REQUEST FOR SEARS
DOOLEY'S LIDCOMBE CATHOLIC CLUB - SSD 7603
AUBURN COUNCIL COMMENTS

Thank you for the opportunity to comment on the draft SEARs for the Dooley's Lidcombe Catholic Club proposal SSD 7603. Council's comments are outlined below in the same structure as the Draft SEARs.

Hotel & Tourist Related Development – Dooleys Lidcombe Catholic Club (SSD 7603) Request for Secretary's Environmental Assessment Requirements

1 DA_ARCH_PHASE 1
1 : 1000

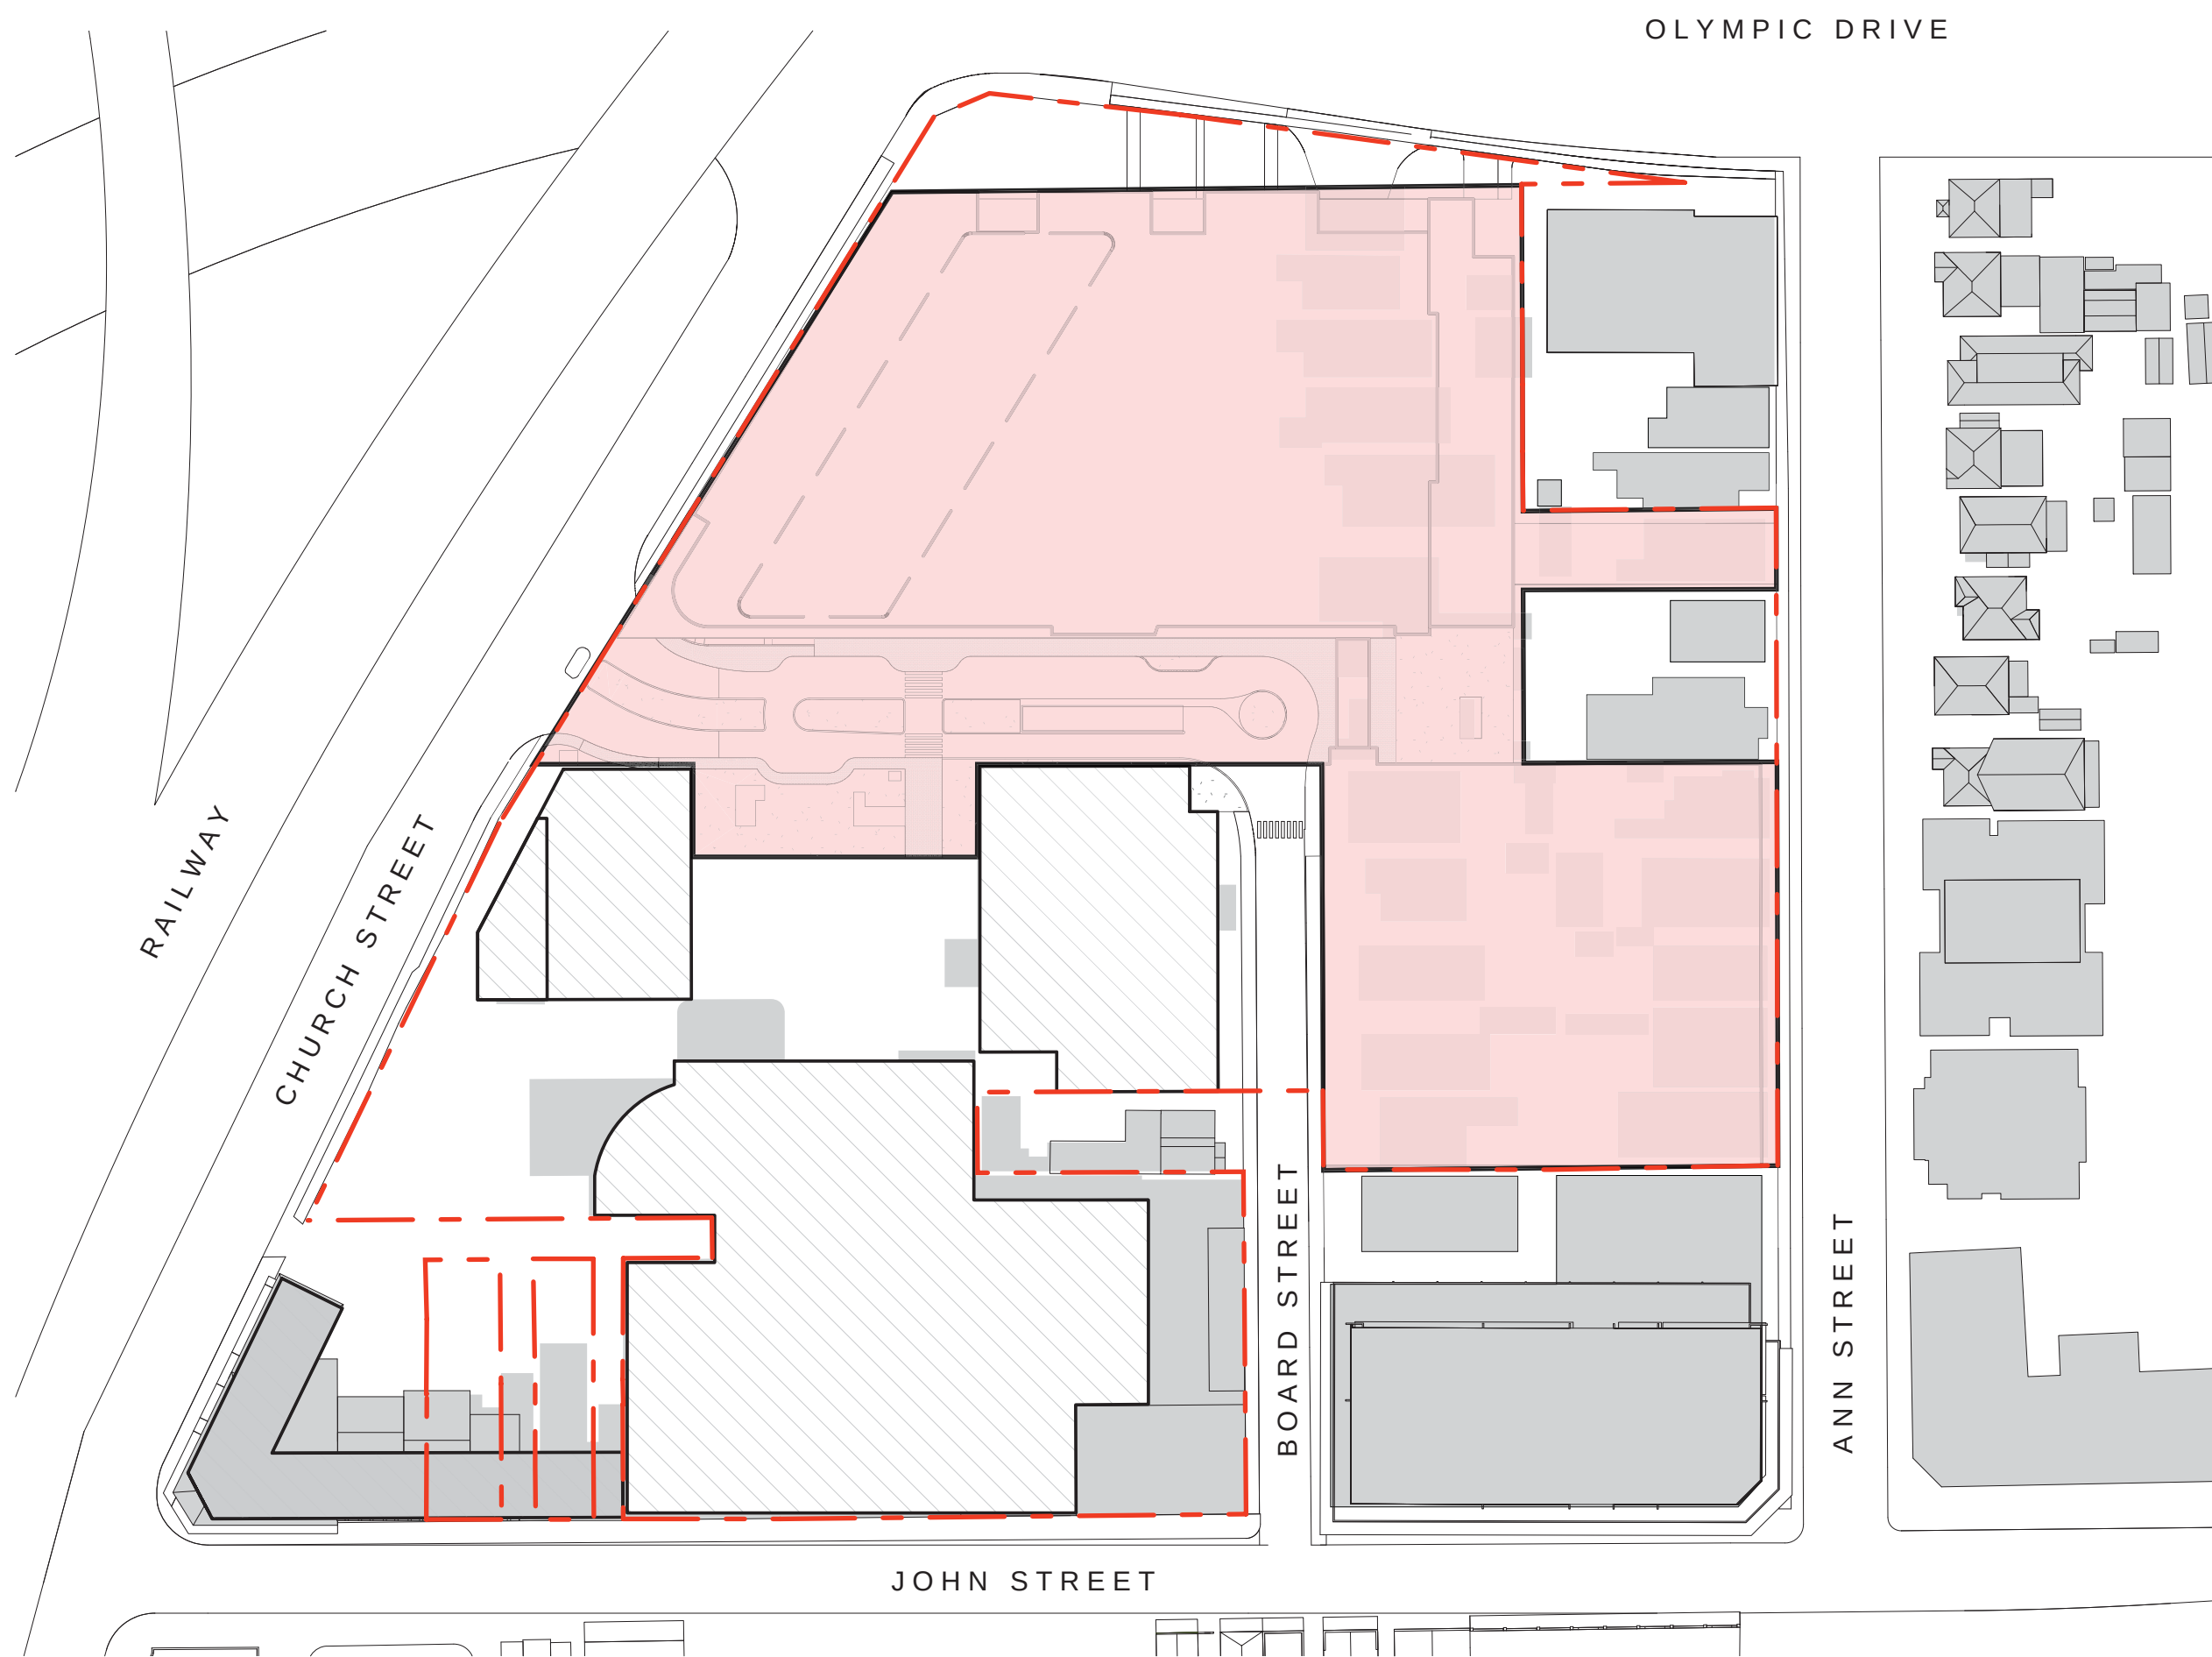
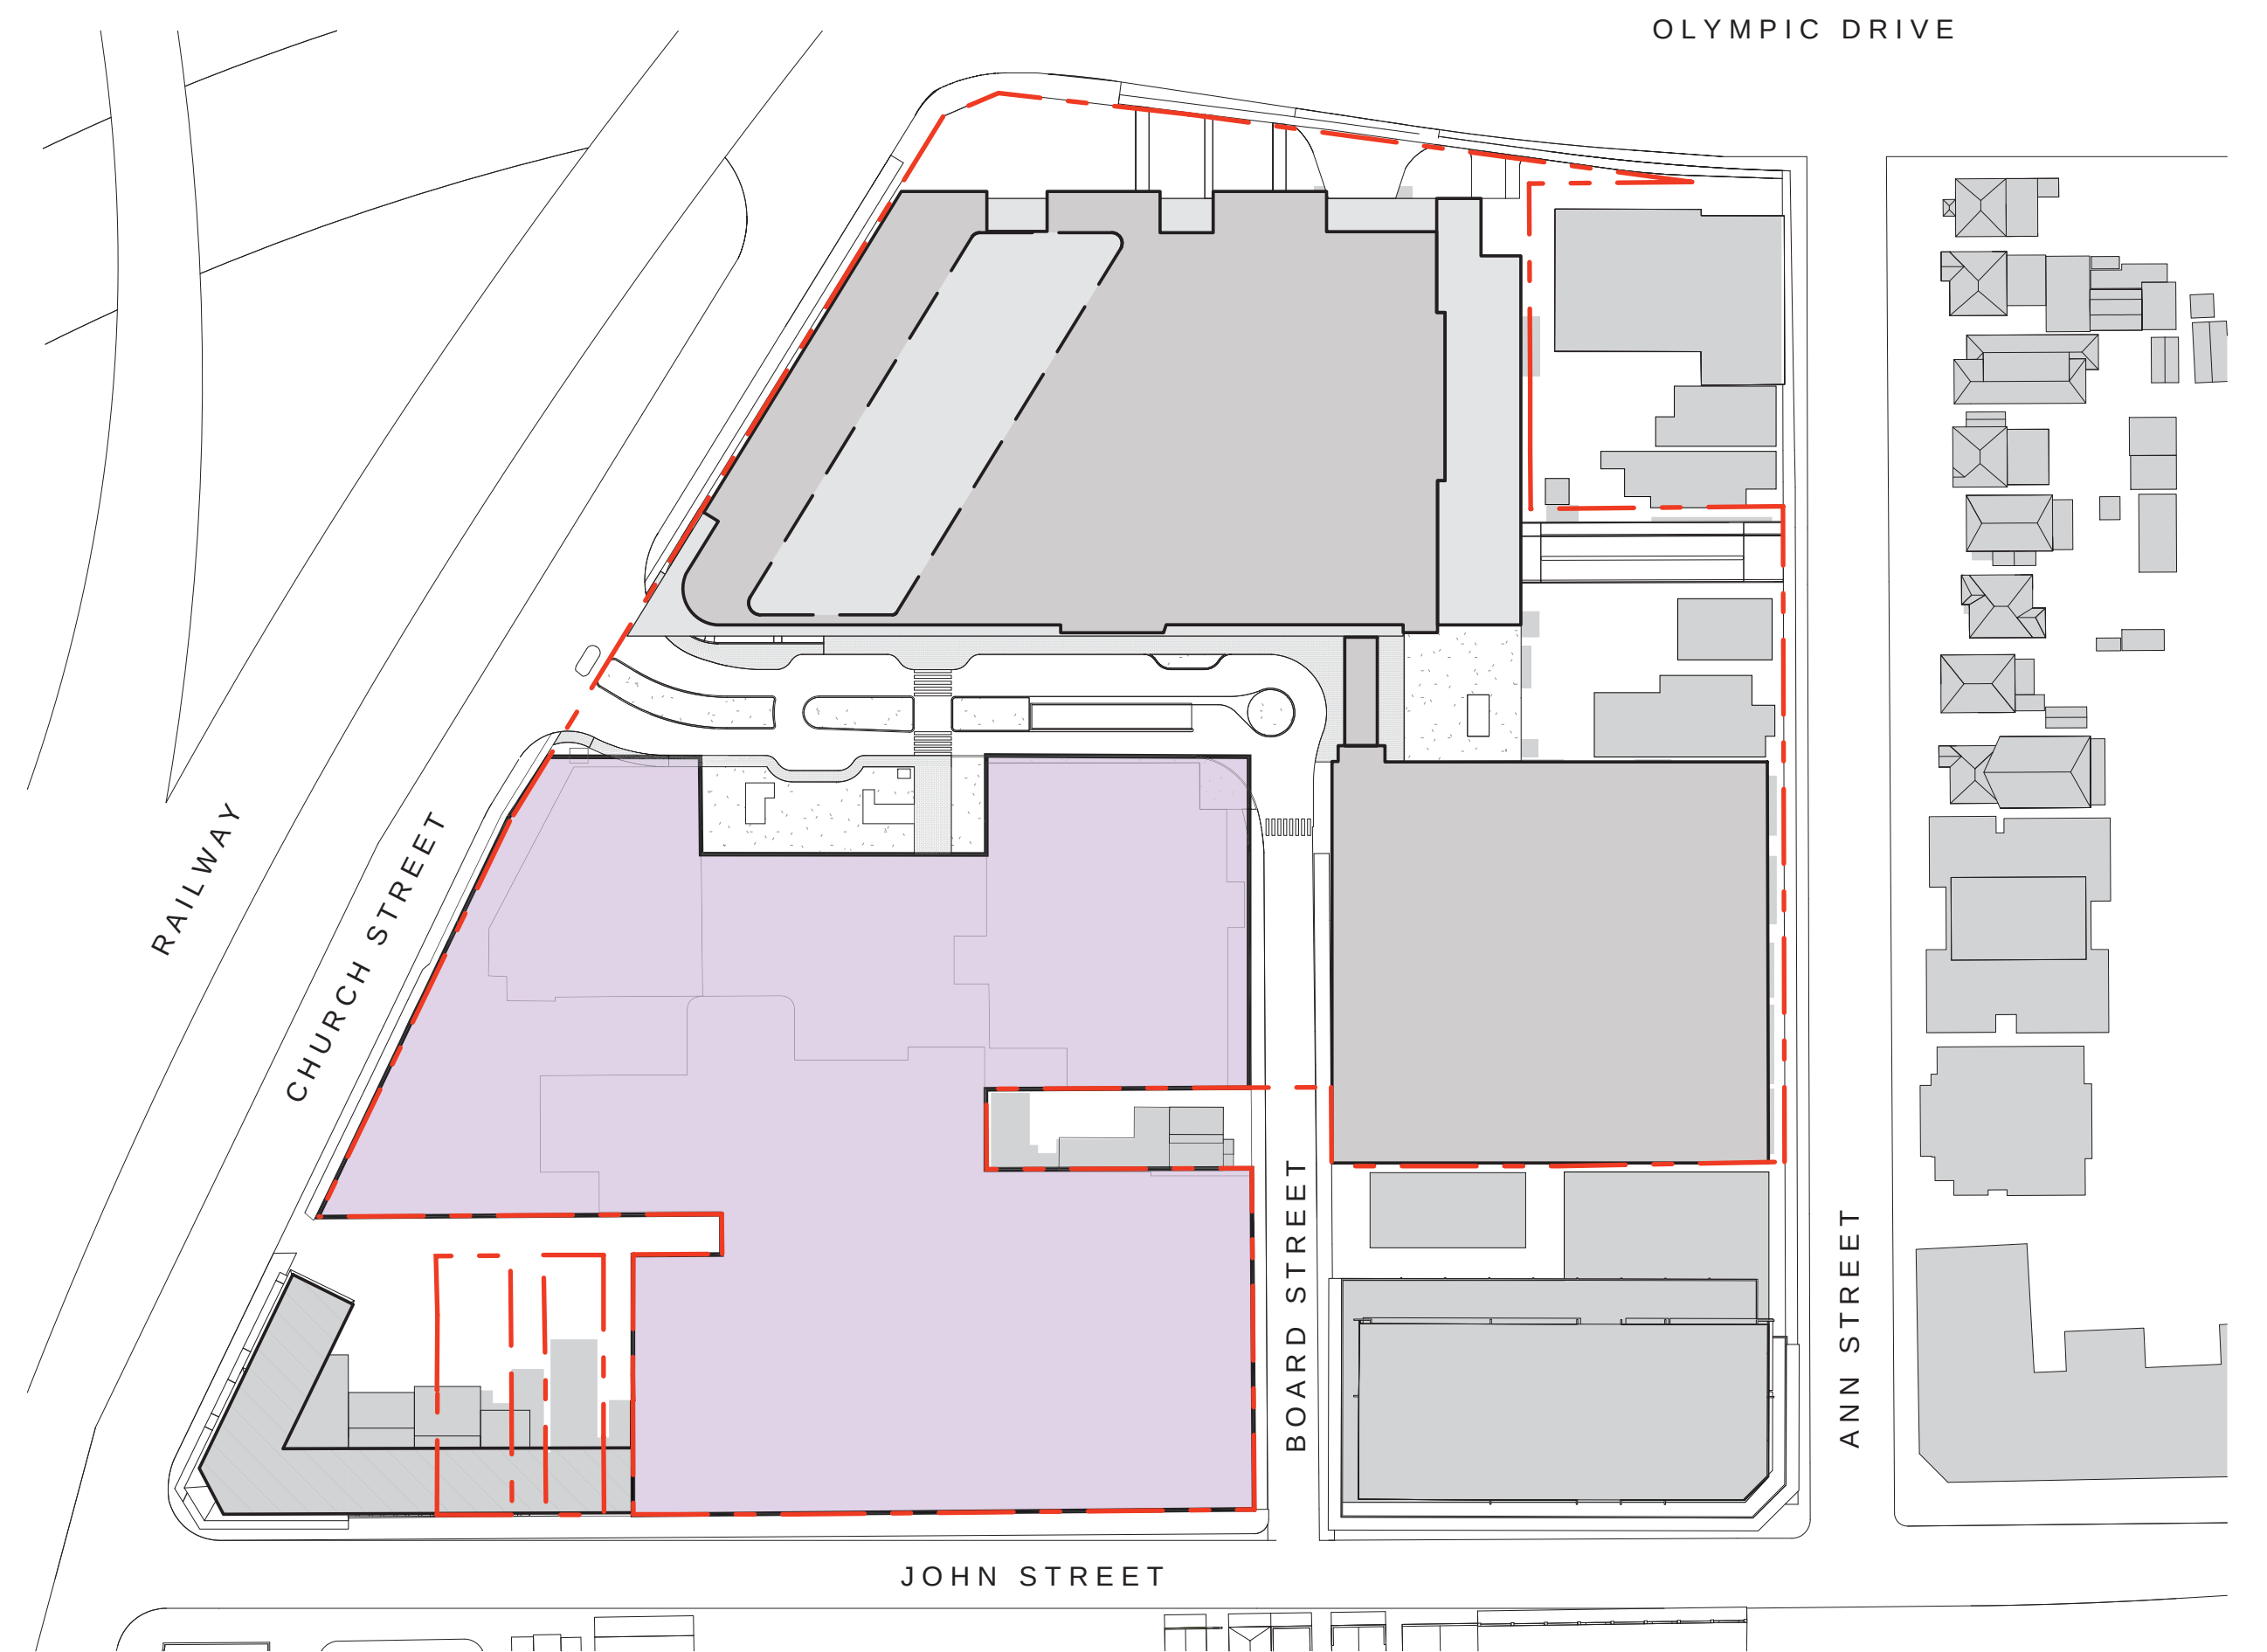
For any major development (including hotel and visitor accommodation) Council **may** consider the staging of payments. If staged/phased development is foreshadowed, as indicated in the Request for SEARs on page 1 and at 2.6 and Figure 6 page 14, then the payment of

Figure 6 on page 14 of the Request for SEARs shows Phase 1 extending over lands that are not owned by Dooleys Catholic Club, namely:

- a. the part of Board St that would be subject to the development (ie the road itself), and
- b. the triangular open space area, zoned RE1 Public Open Space, between the existing club site and Olympic Drive.
